Our Ref: BR/193/18/L
Your Ref:

Application for Listed Building Consent for Alterations, Extension or Demolition of a Listed Building

Development Listed building consent for the fitting out of 2 No. Edwardian waiting rooms into a modern office space with meeting rooms, toilets & kitchen, incorporating original elements of the building, mezanine floor installed in larger office, new heating, ventilation & air conditioning in office spaces.

Location Bognor Regis Railway Station Station Road Bognor Regis

Location Plan of Po21 1Bp

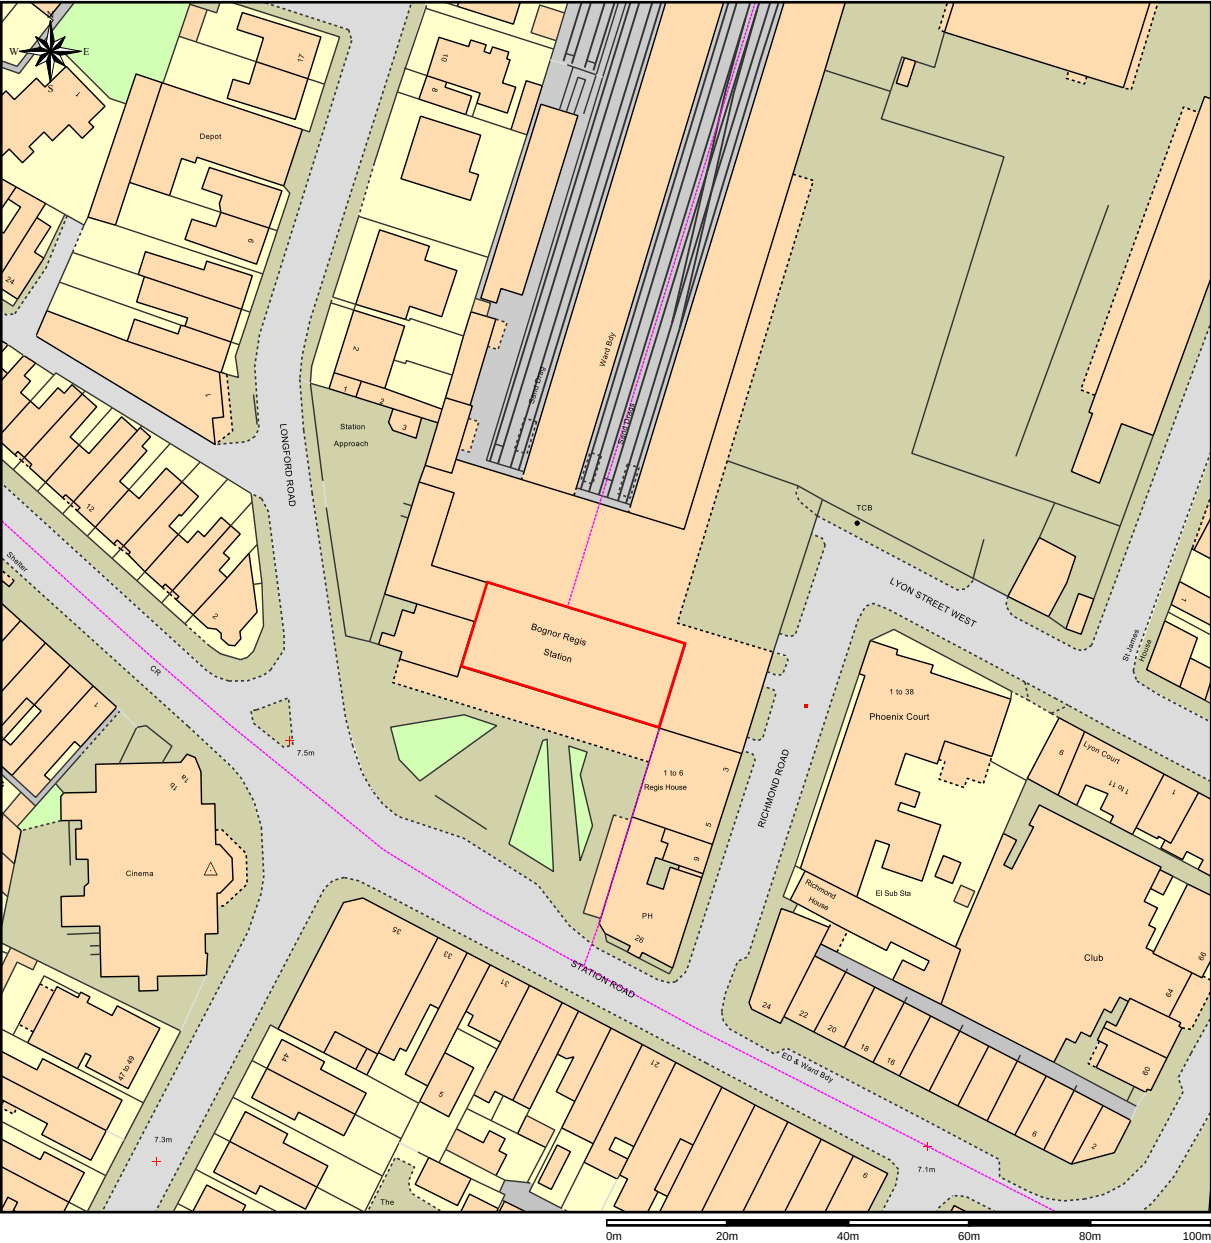
Location Plan Amend

Please red edge the application site.
